**Application by Highways England for an Order Granting Development Consent for the A38 Derby Junctions Scheme**  
**The Examining Authority's issues and questions for Issue Specific Hearing 2**  
**Issued on 3 December 2019**

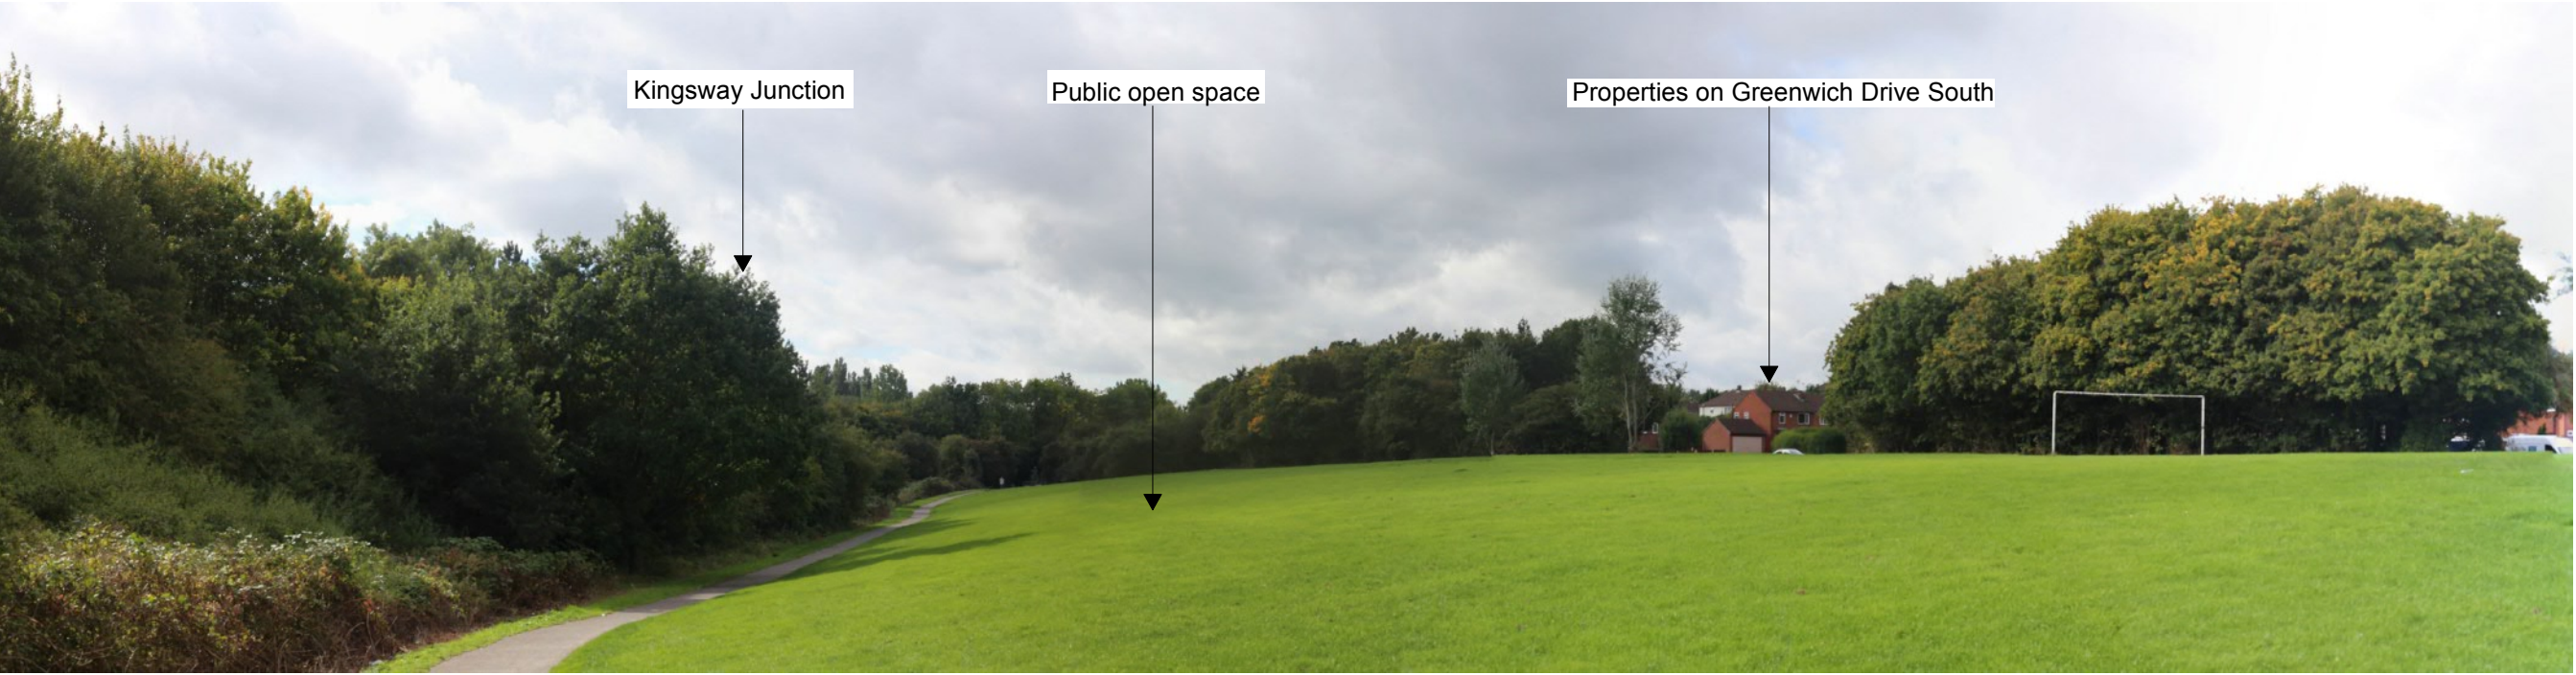
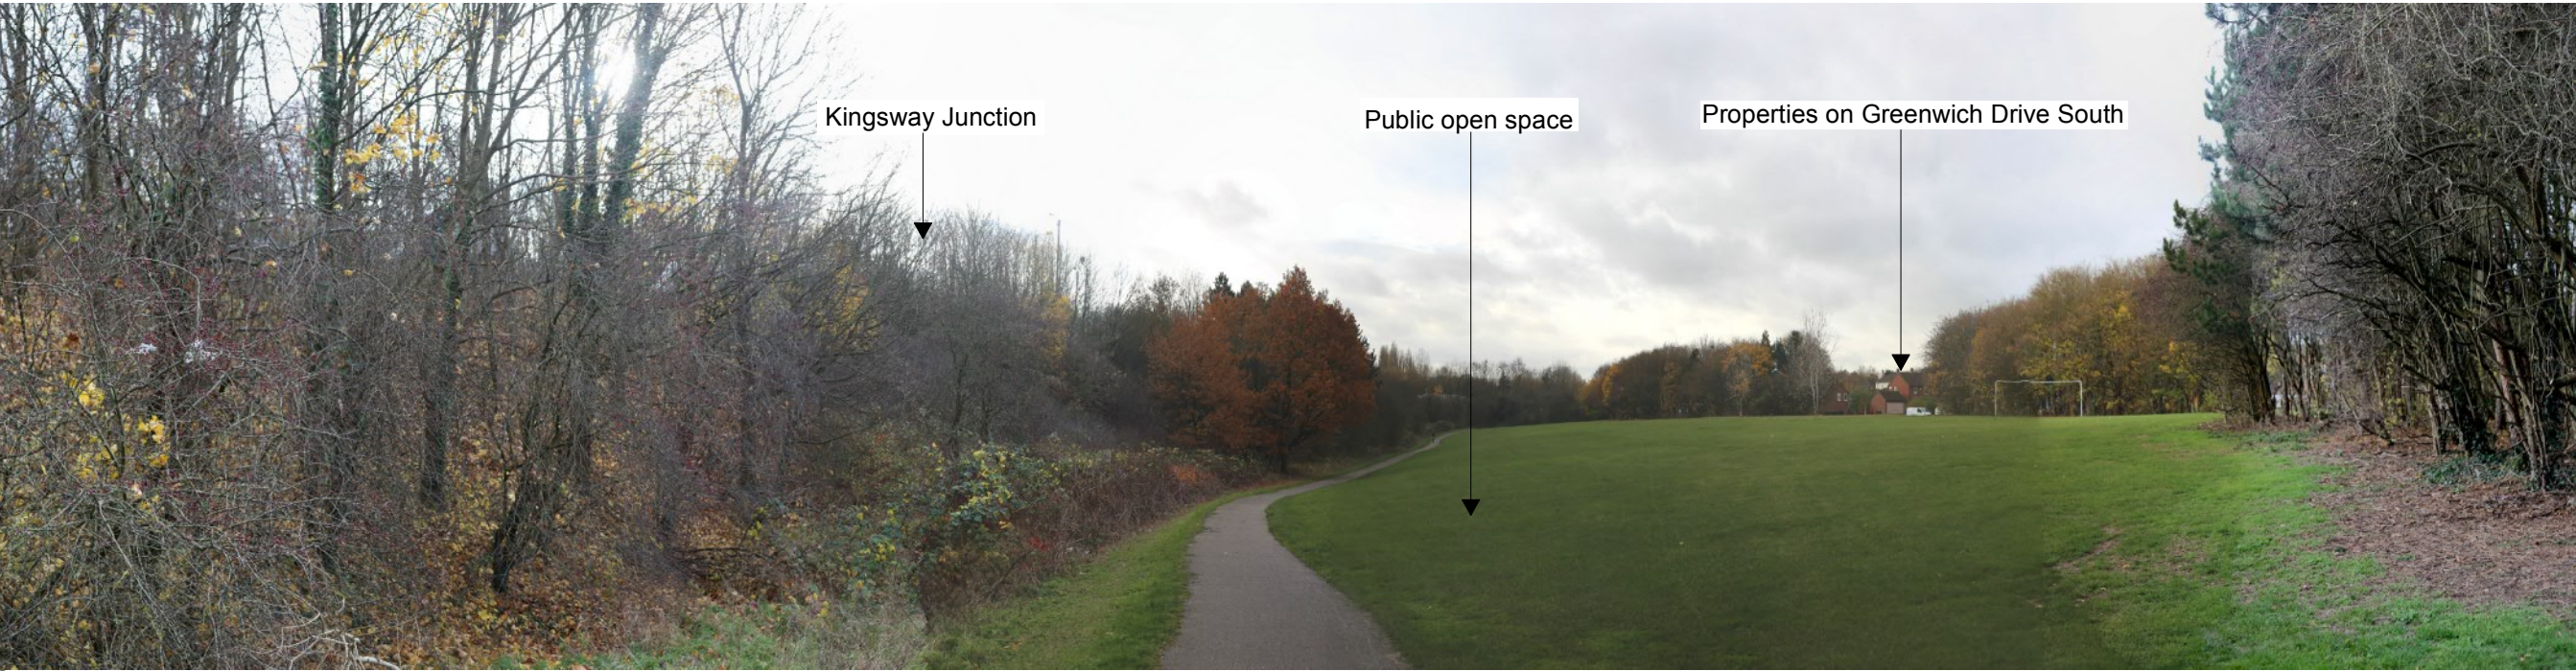
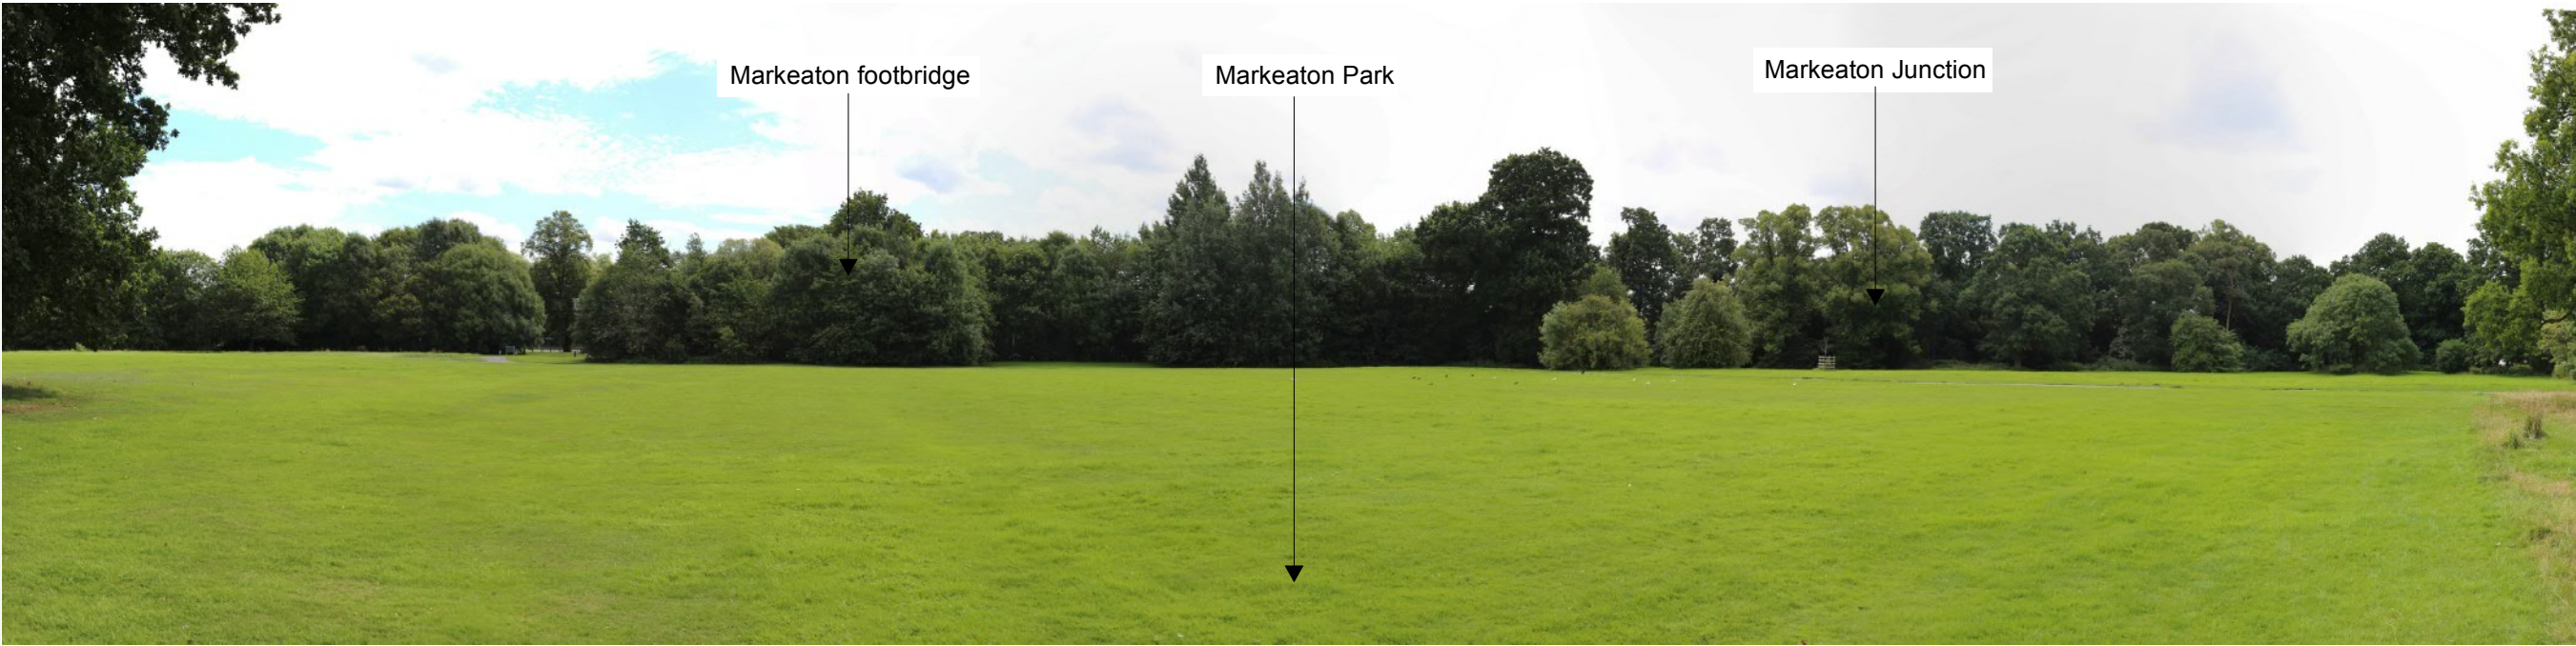
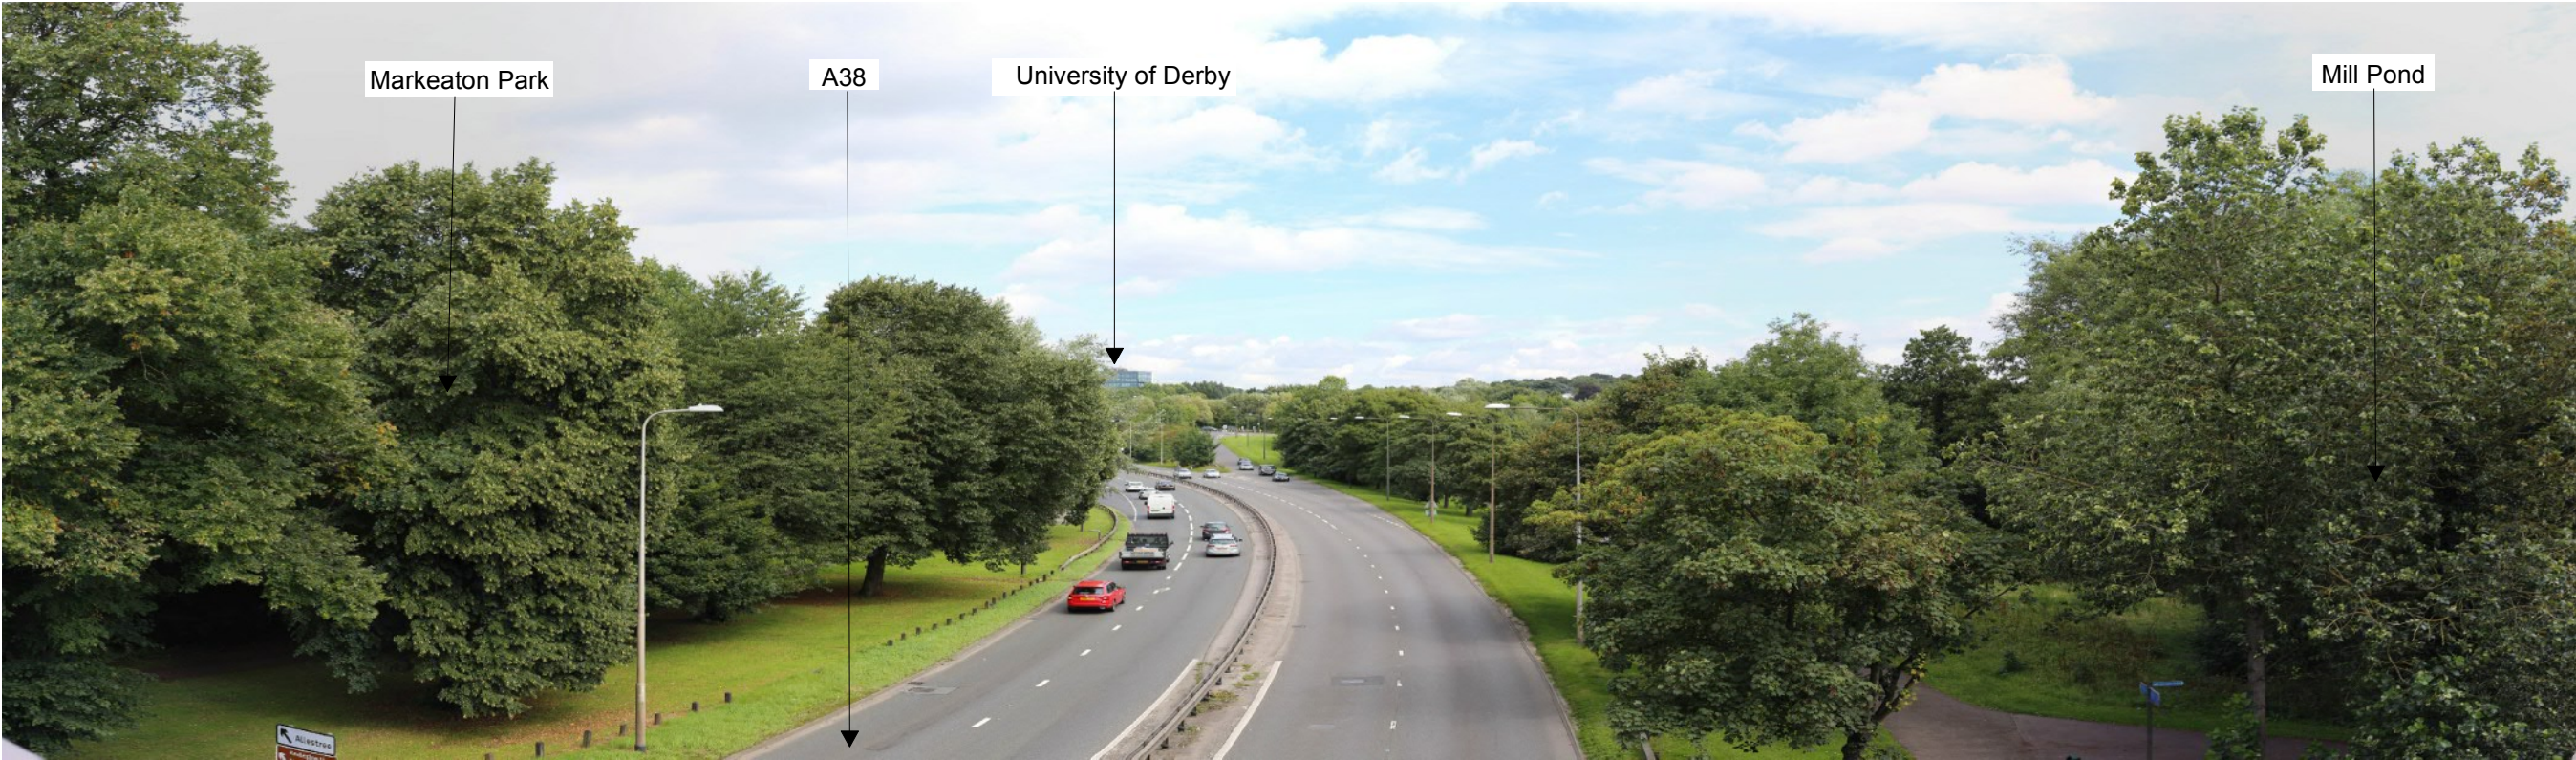
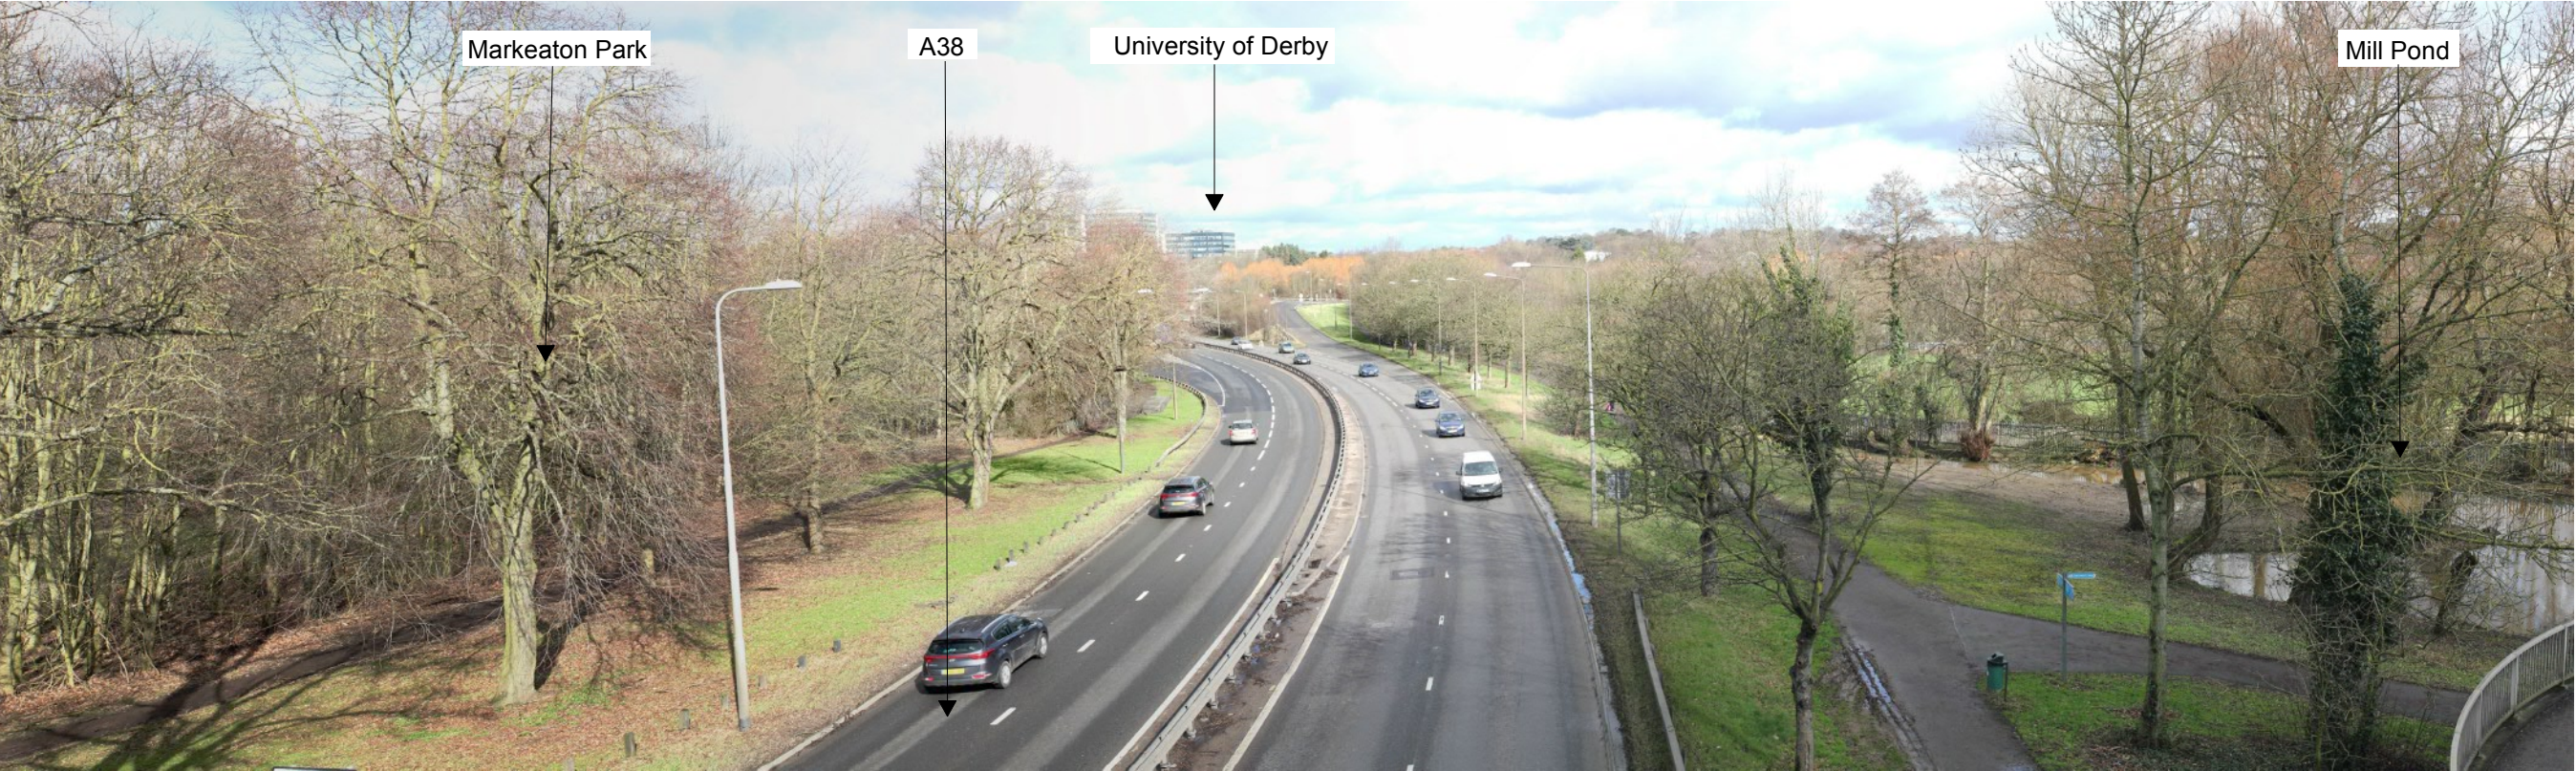
28.	<p>Whether the methodology used in the landscape and visual assessment properly reflects the impacts of the proposals ExA issue / question [PD-003] Q9.1, Q9.7 Applicant response [REP1-005] DCC response [REP1-030] DCiC response [REP1-034] ES Figure 7.5a [REP2-011] Additional Photomontages [REP2-021]</p>	<p>a) Update on the additional photomontages based on the North Avenue Inquiry. Issues, outcome and relevance of that Inquiry. b) Do the revised representative viewpoints and new photomontages allow the landscape and visual impacts of the proposal to adequately assessed?</p>
